STATE OF MAINE
DEPARTMENT OF TRANSPORTATION
16 STATE HOUSE STATION
AUGUSTA, MAINE 04333-0016

July 8, 2011
Subject: **Portland Marine Terminal**
Federal Project No: DTMA1G10006/TIGER
State PIN: 017820.00
Amendment No. 4

A.A1

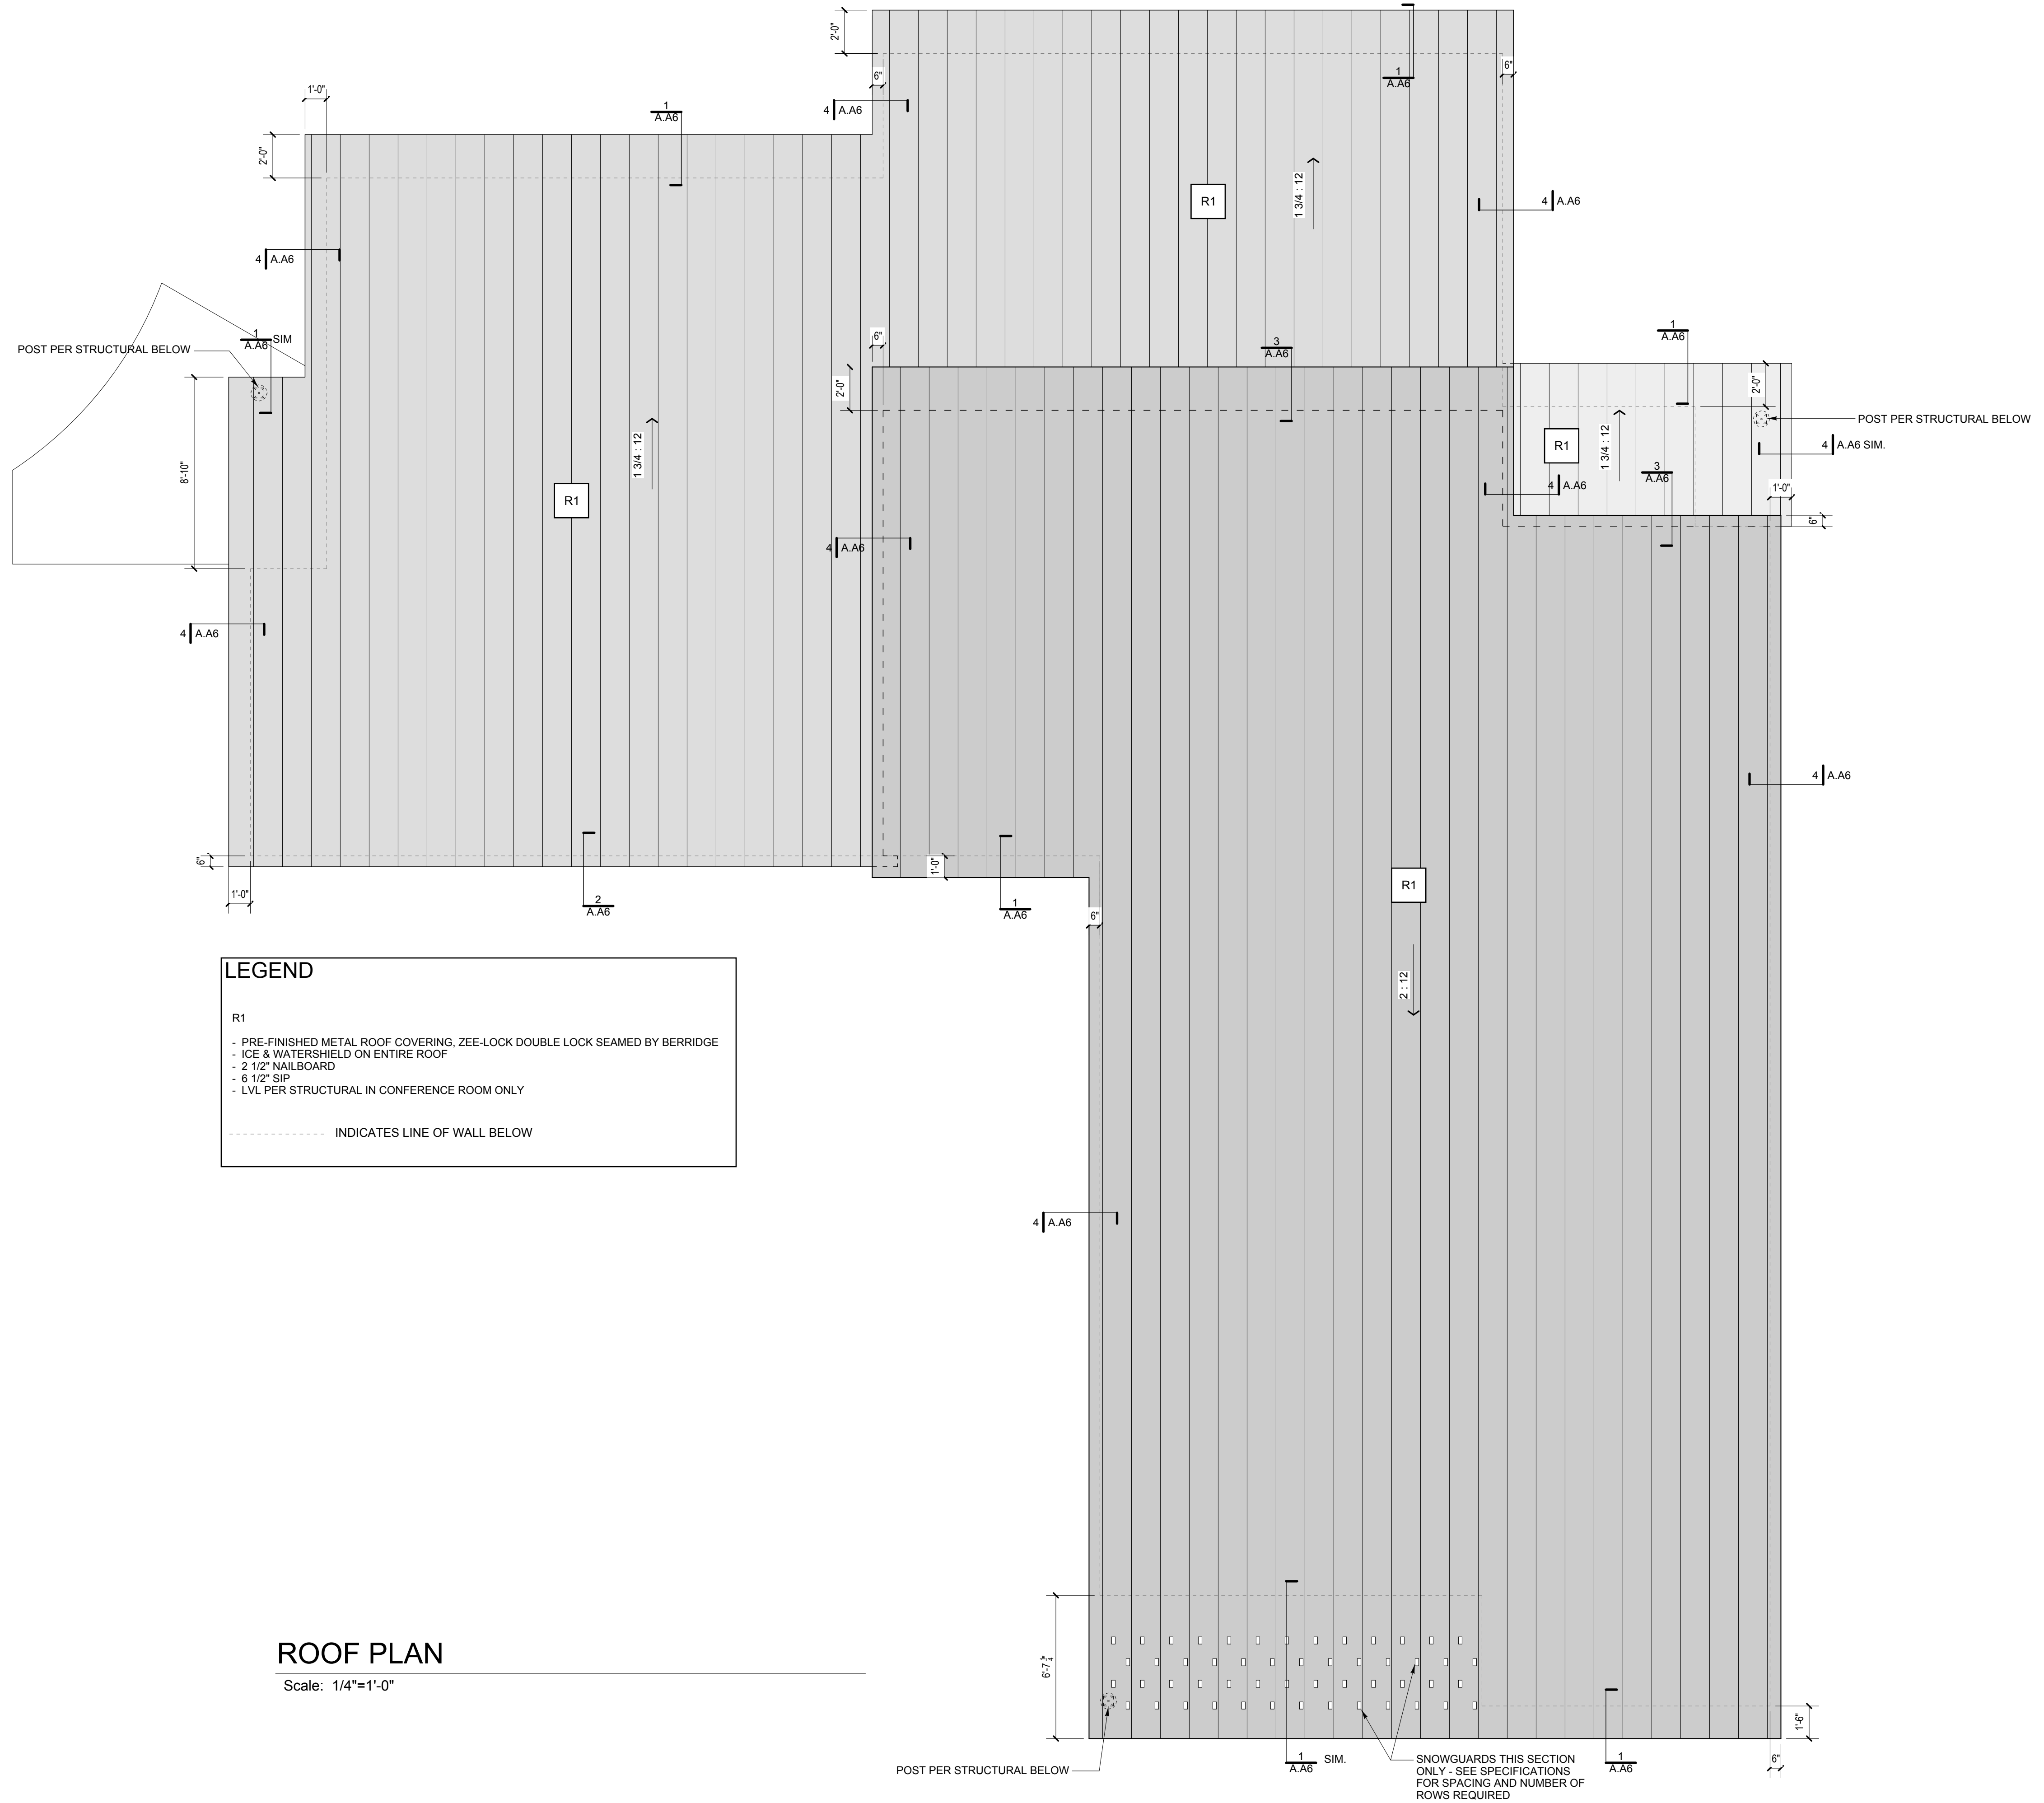
Question: On Sheet A.A1, the Security Office has a type W1 and type W2 window. These windows are not shown on the window schedule or the door and frame schedule. Please clarify.

Response: Interior windows "W1" and "W2" are shown on the Ground Floor Plan on Sheet A.A1 and on interior elevations A/A.A12, 4/A.A13, and 1/A.A13 but they do not appear on the door and frame schedule on Sheet A.A9.

W1 is a fixed glass unit with hollow metal frame as shown in the attached sketch.

W2 is a hollow metal frame with sliding glass panels as shown in the attached sketch.

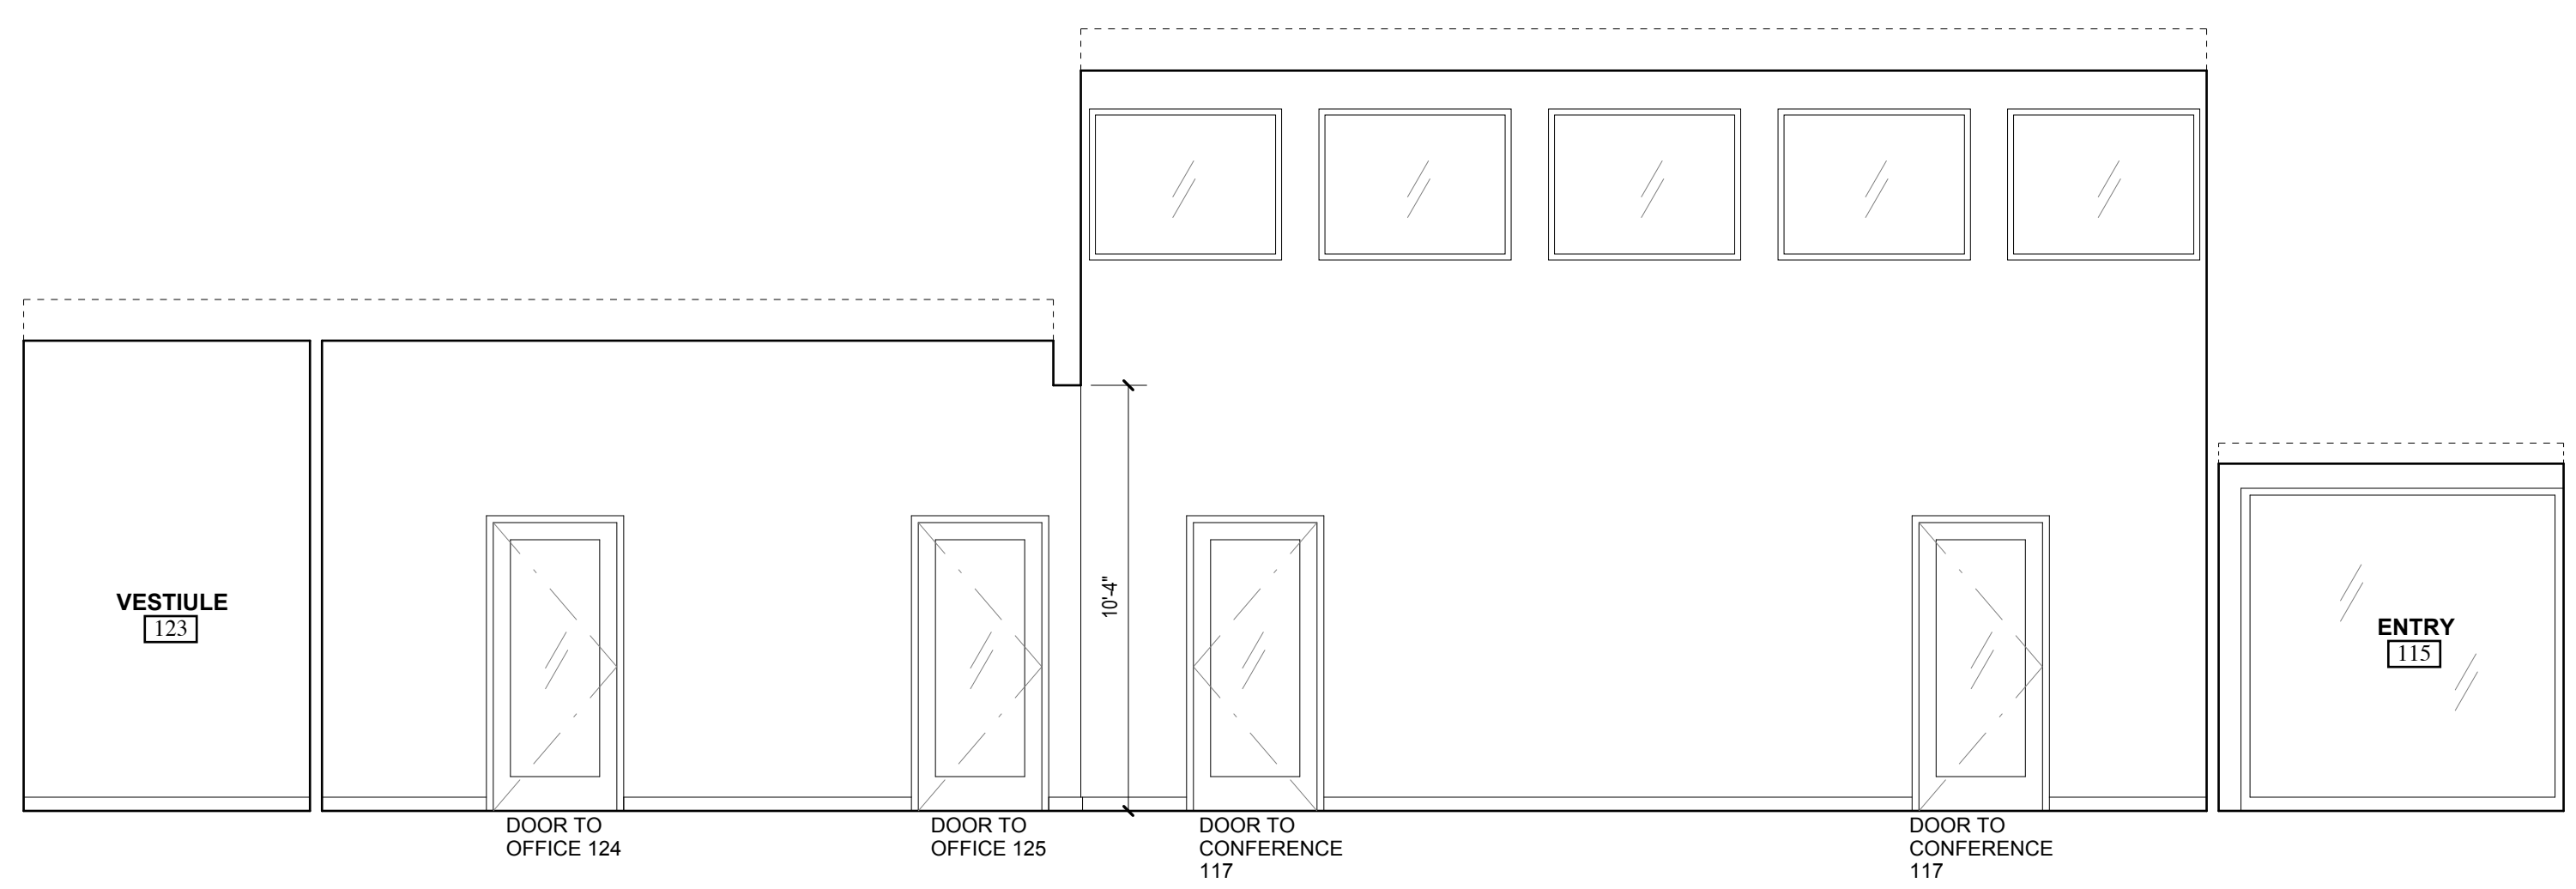
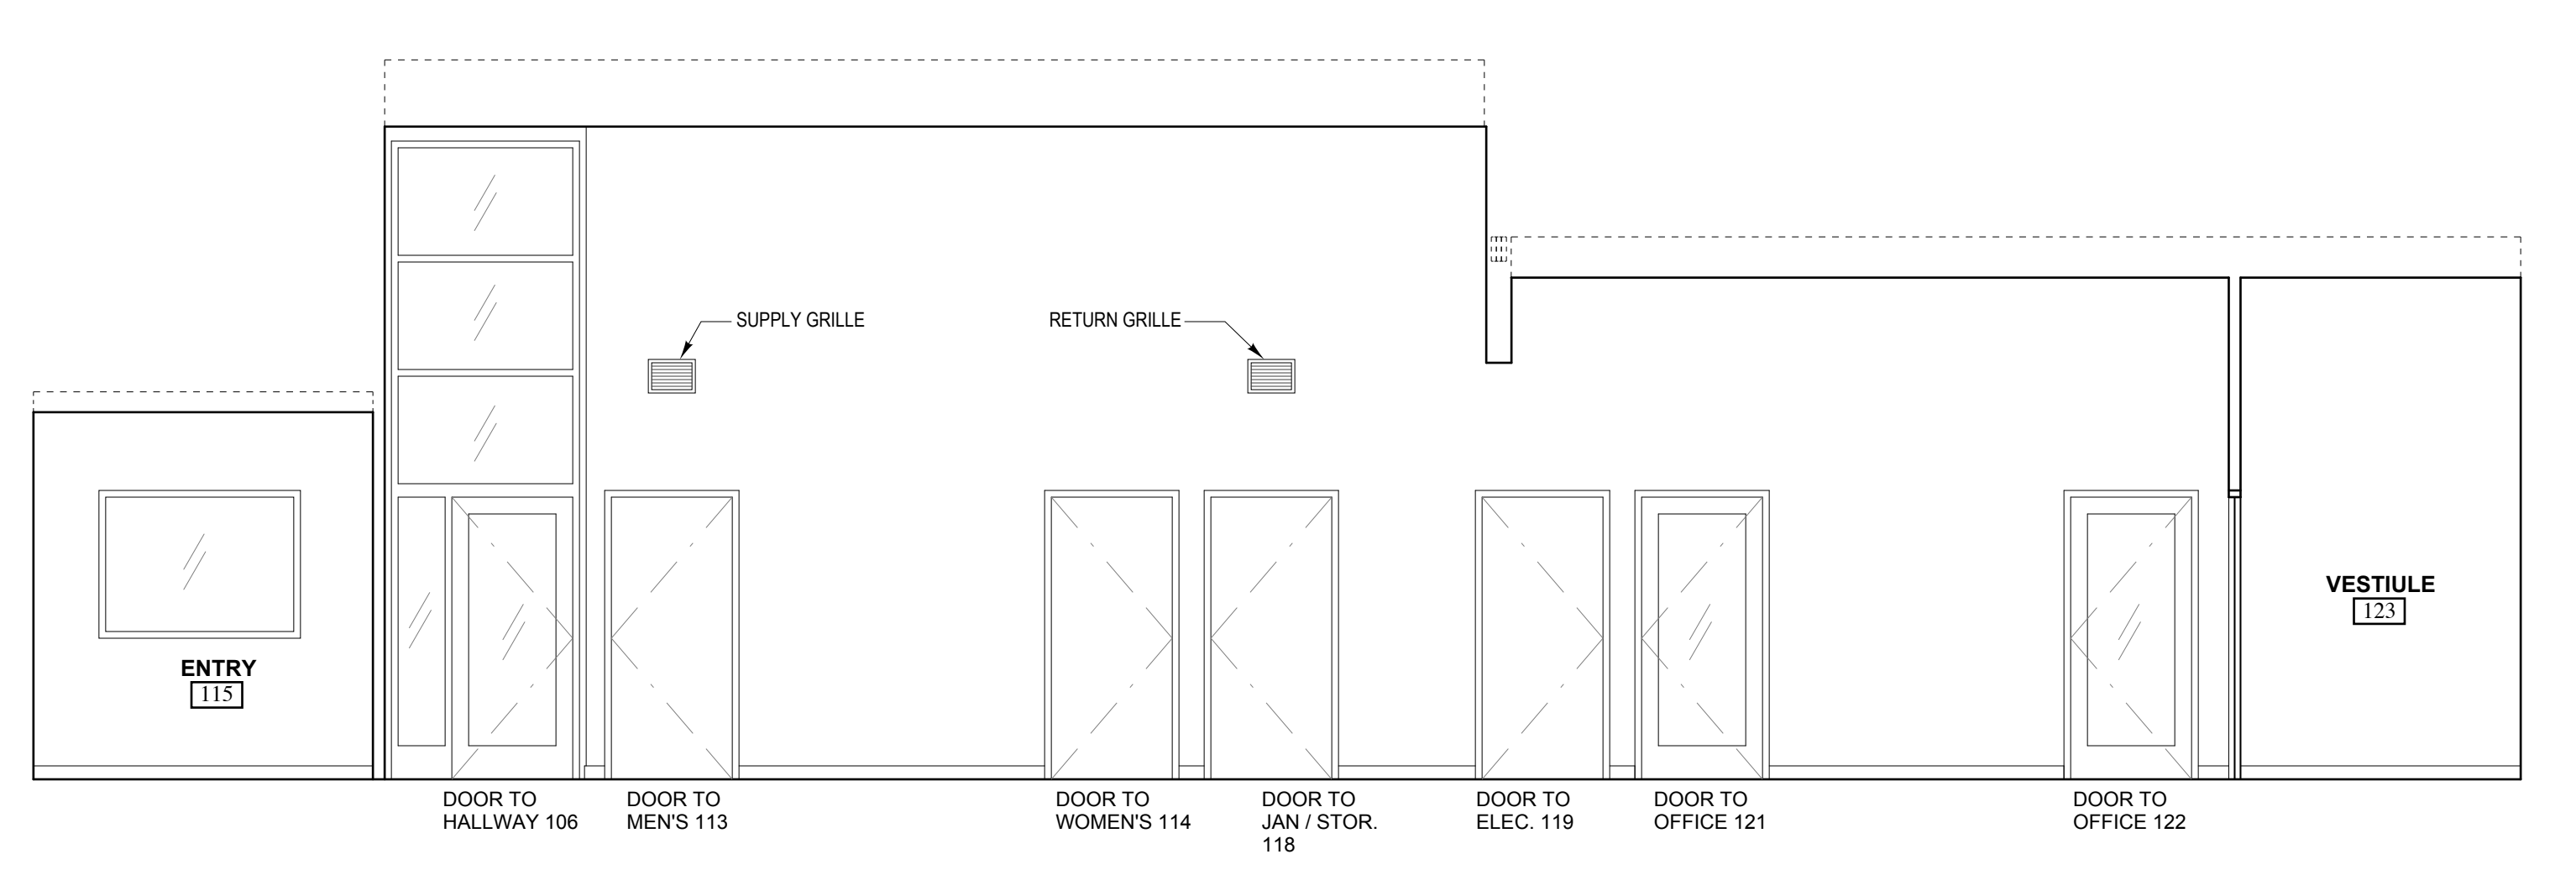
Question: Reference drawing A.A1 in room 107 "Entry" – there are several items shown on the walls (North and West), what is indicated? These items are also shown on the interior elevation 2-2 and 2b on Plan Sheet A.A12.

Response: The items shown on the interior elevations of entry 107 are a built-in bench and a built-in overhead with coat hooks. The bench is described in Detail 4 on Sheet A.A10 and the clear finished wood referenced in the notes refers to maple. A detail of the shelf was not provided. See attached sketch for shelf detail.
